From: Simon Davis
Sent: 14 February 2025 10:14
To: Robert Collett [REDACTED]
Subject: RE: AL/143/24/RES Land adj Woodgate Nurseries

AL/143/24/RES

Outline Conditions

Title: Play and Open Space Proposals Sheet 1

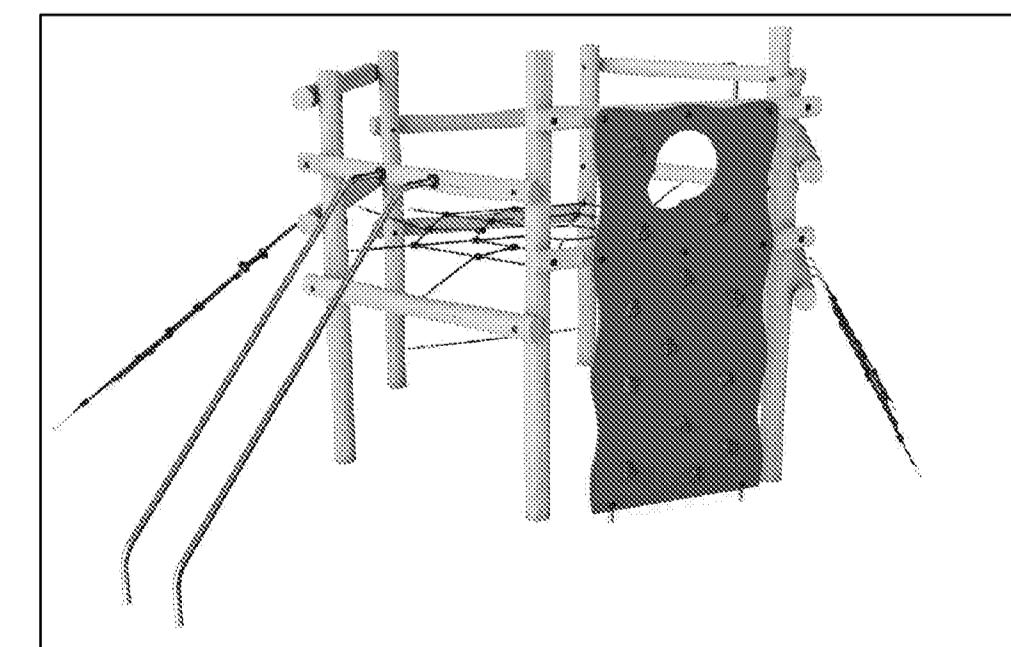
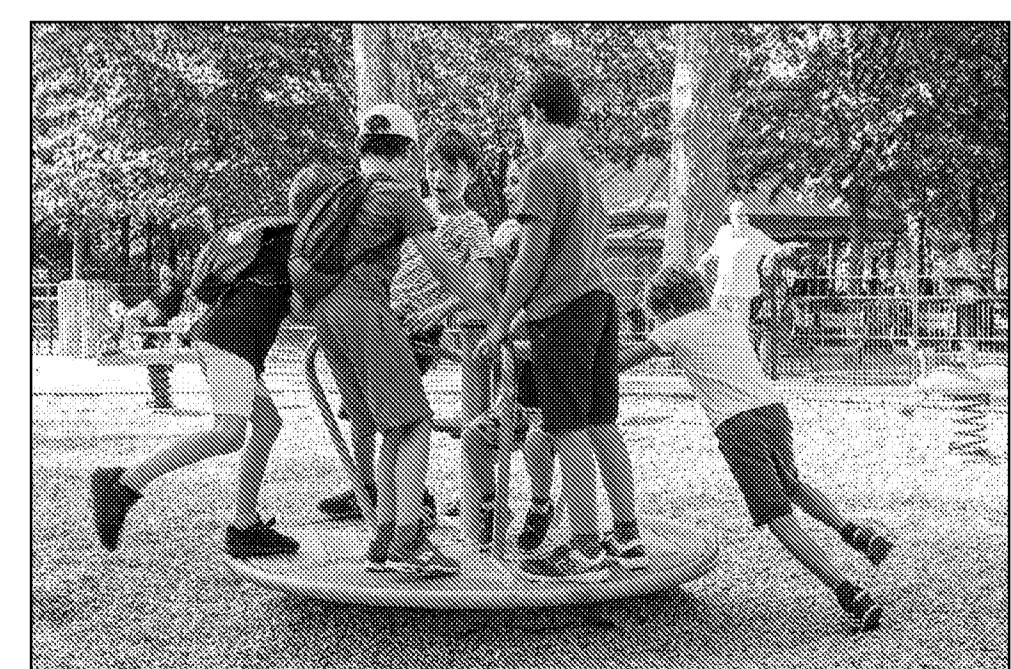
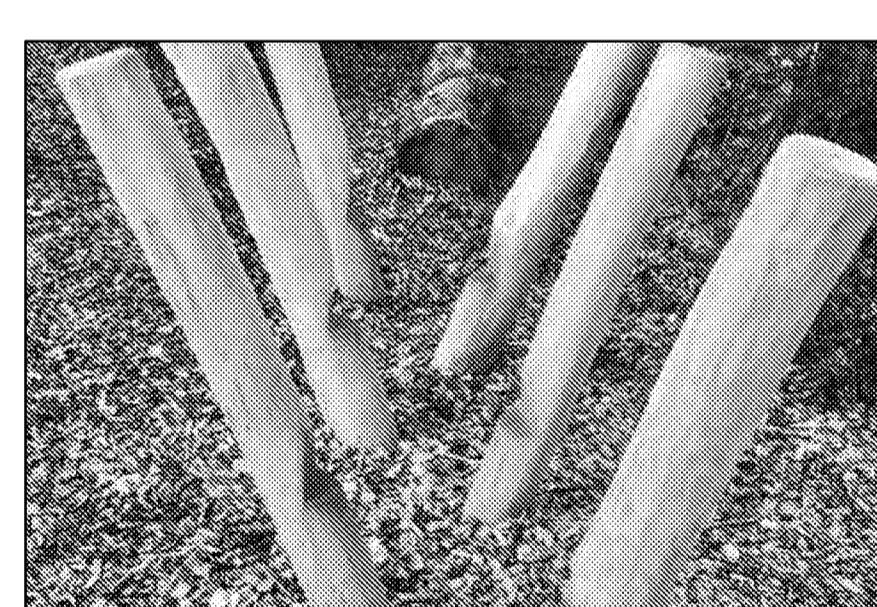
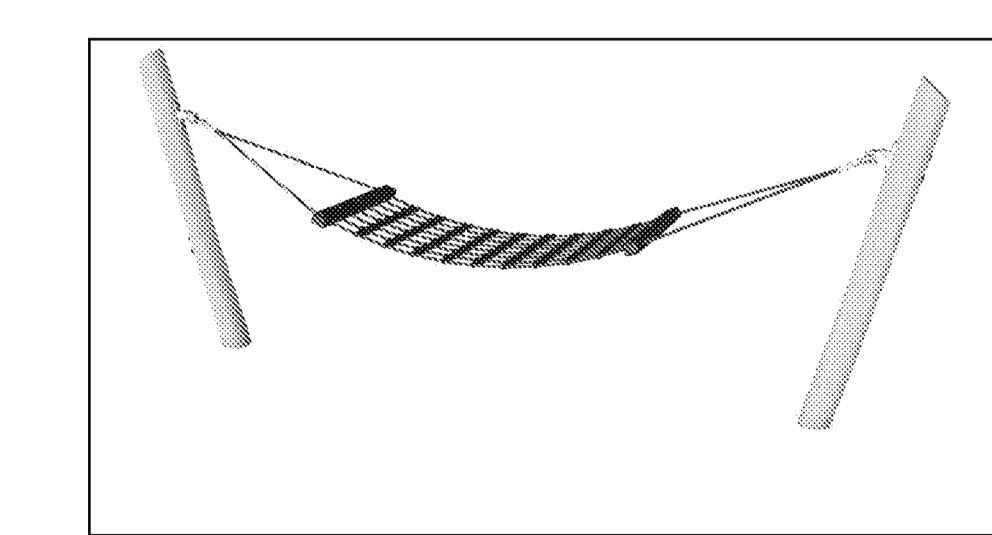
Provide LEAP and 2 x LAP (which are all spread out) and state they meet the POS requirements but no info on proposed amount of open space in m² (no breakdown of areas to check whether useable). Await Landscape comments
